BUILDING PERMIT REPORT

DATE: 15 Dec 98 ADDRESS: 72 Torrington Ave. CBL 084-N-014
REASON FOR PERMIT: Amend original permit #970537
BUILDING OWNER: Kane
CONTRACTOR: Scottsdale Const
PERMIT APPLICANT: owner
USE GROUP R-3 BOCA 1996 CONSTRUCTION TYPE 5 B

72 Torrington Ave.
 2nd Floor Proposed Plan
 Dec. 1998

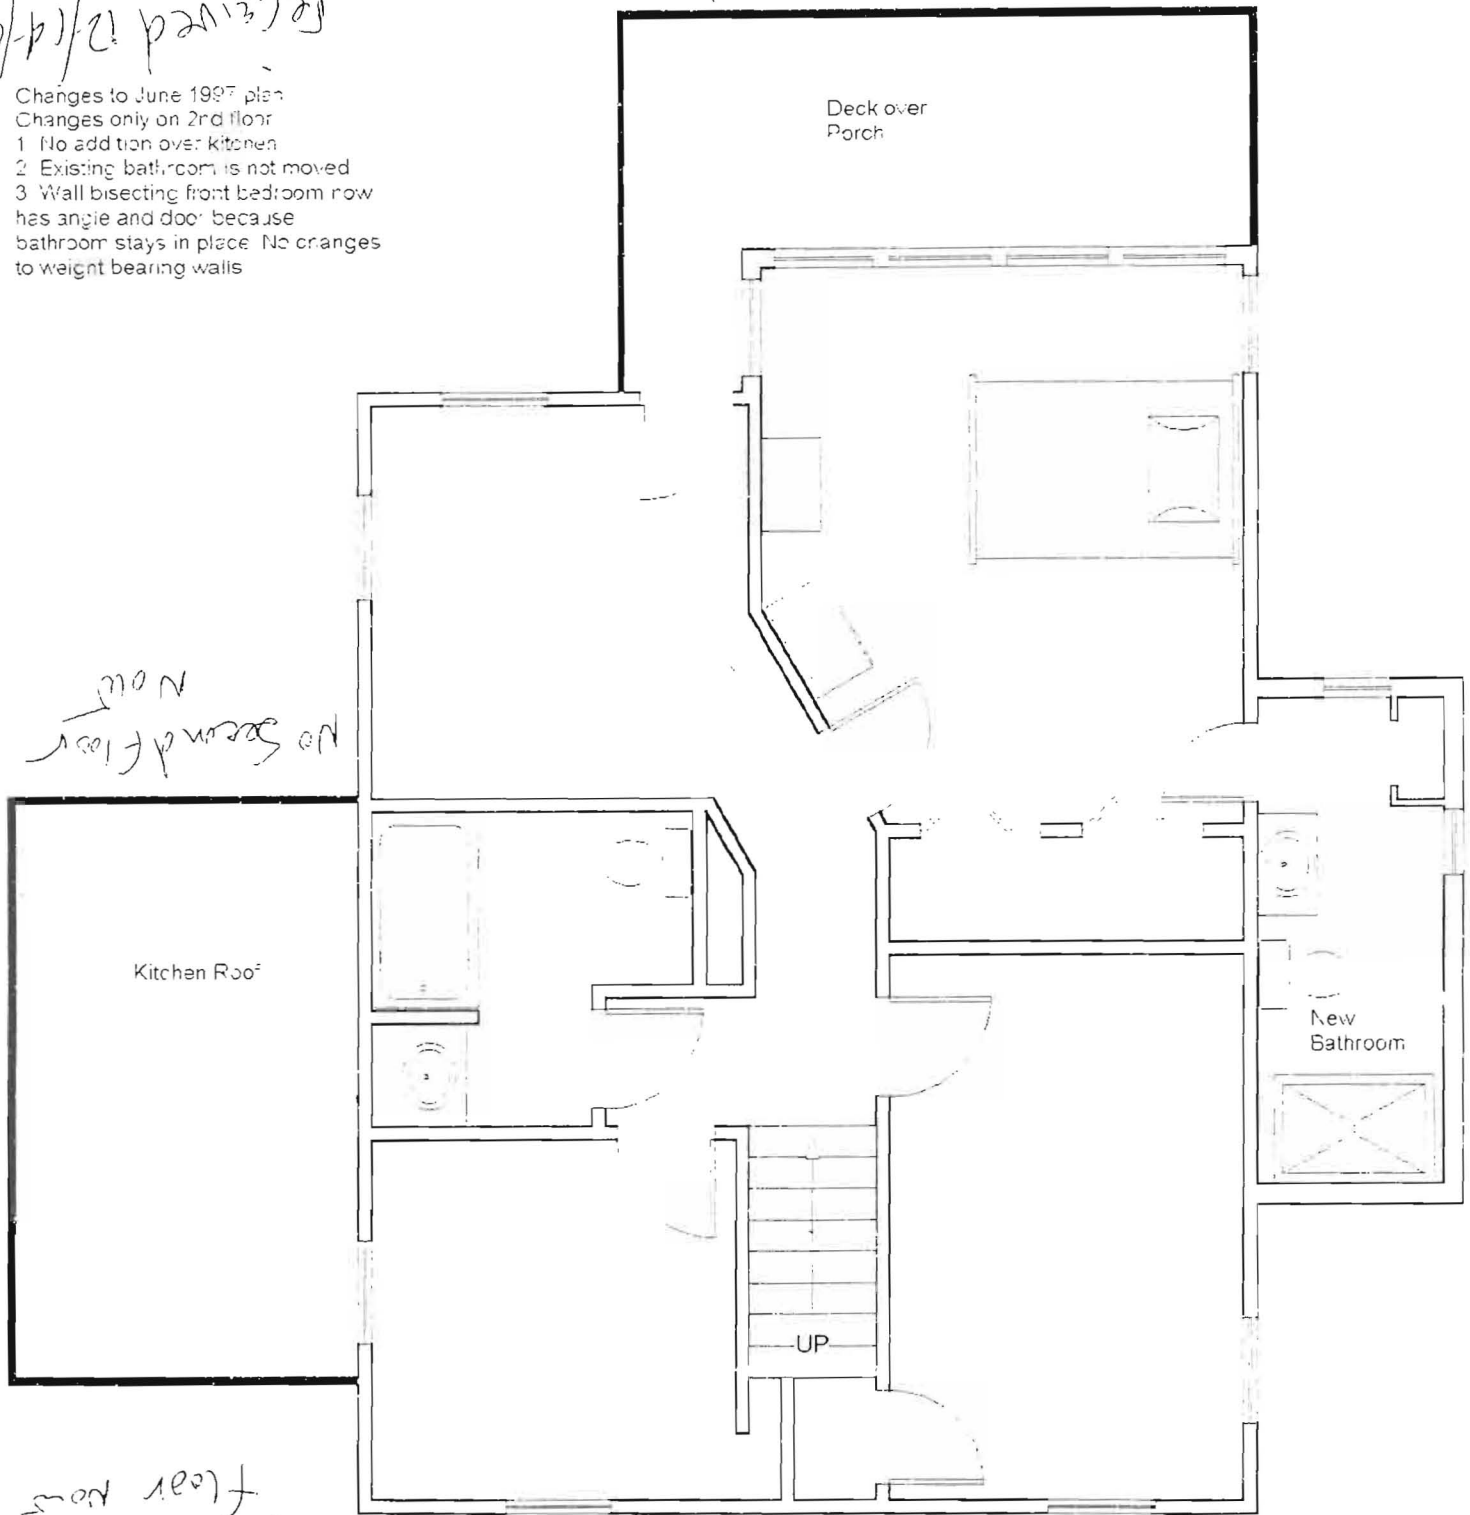
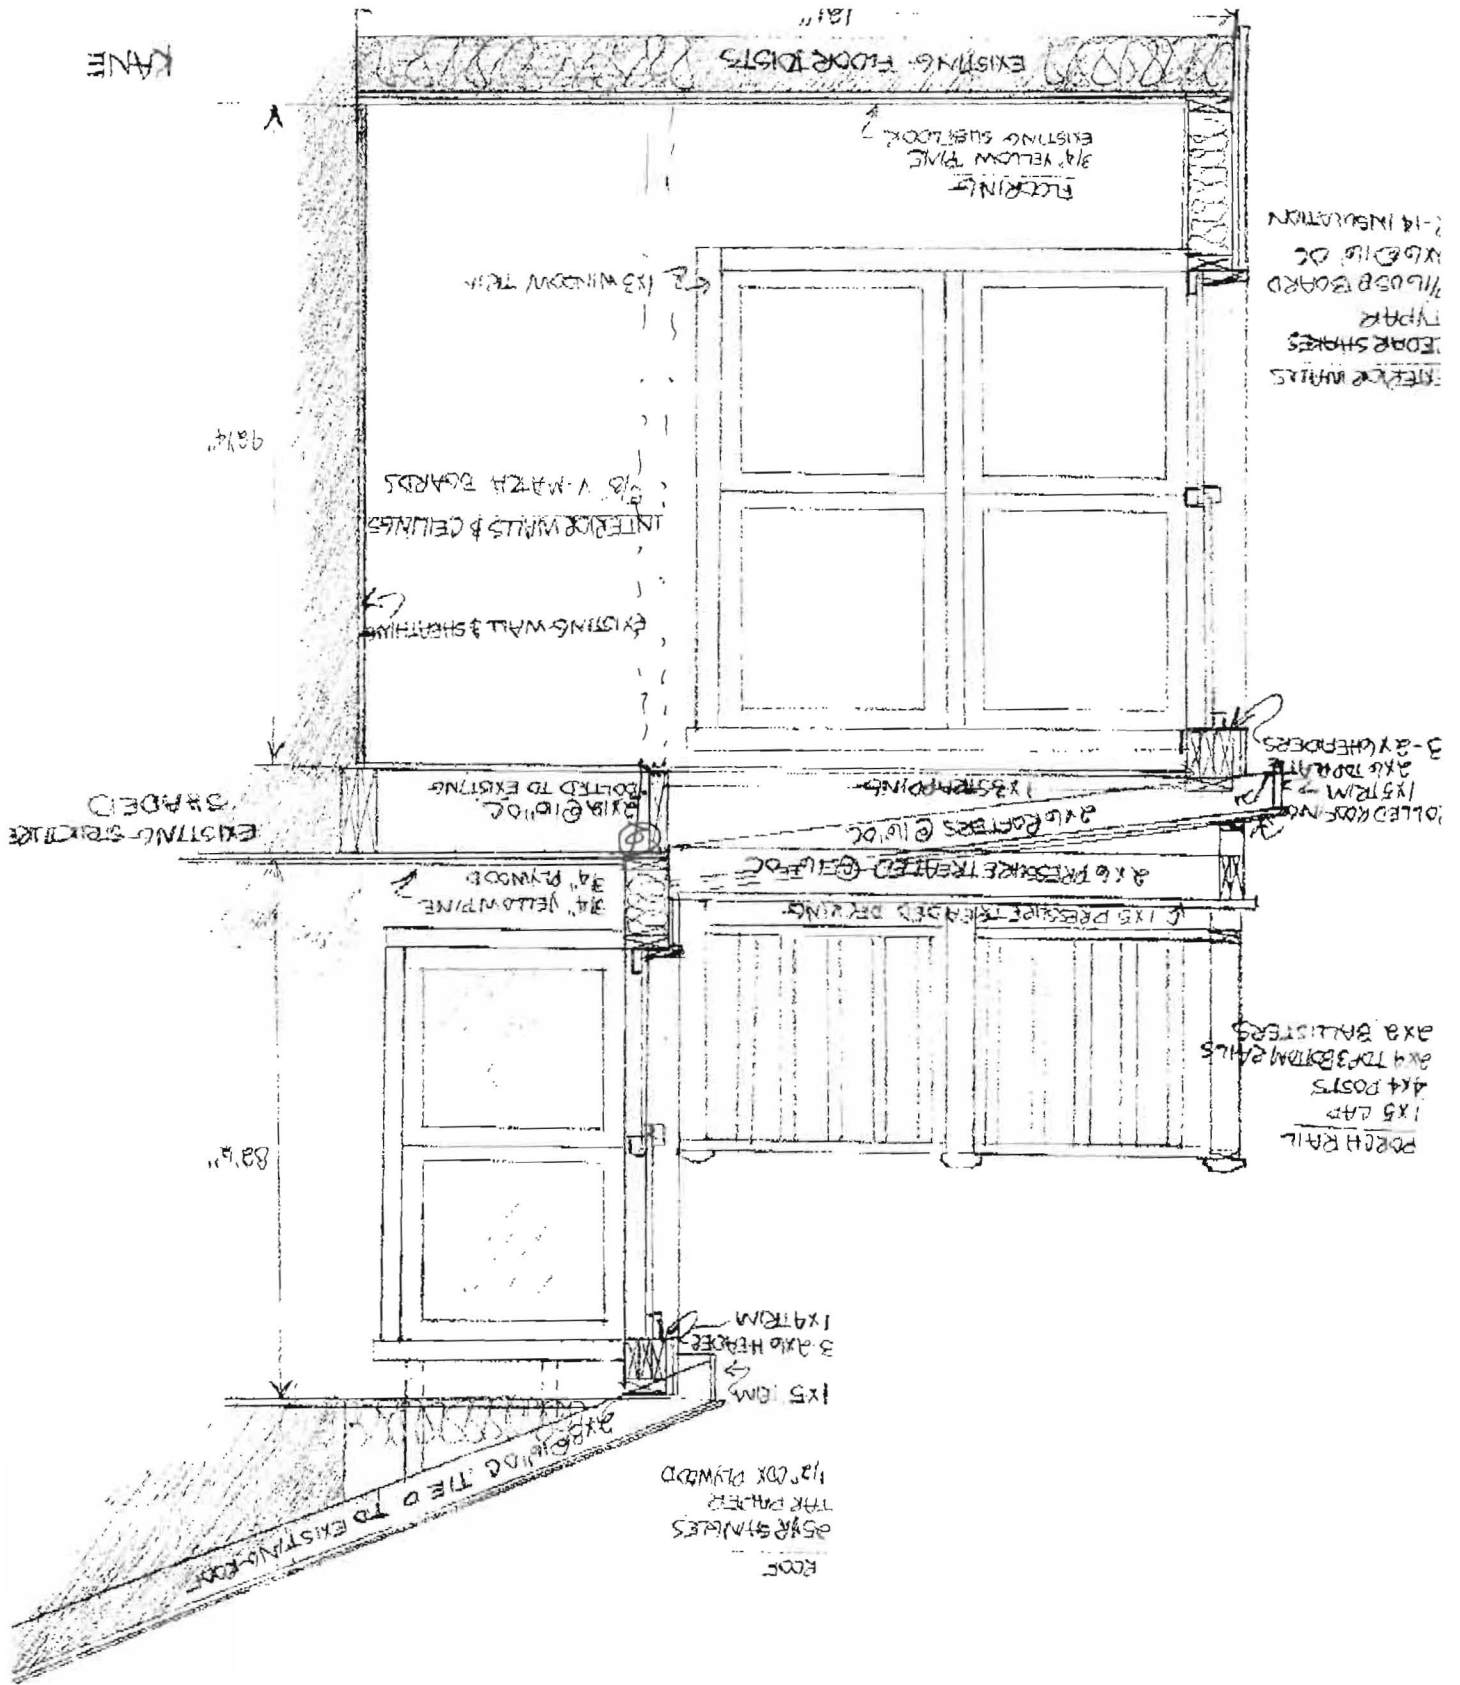
*31. Your plan did not show a Framing detail of The expansion of The Second Floor bedroom over the porch - Please submit this detail as soon as possible -
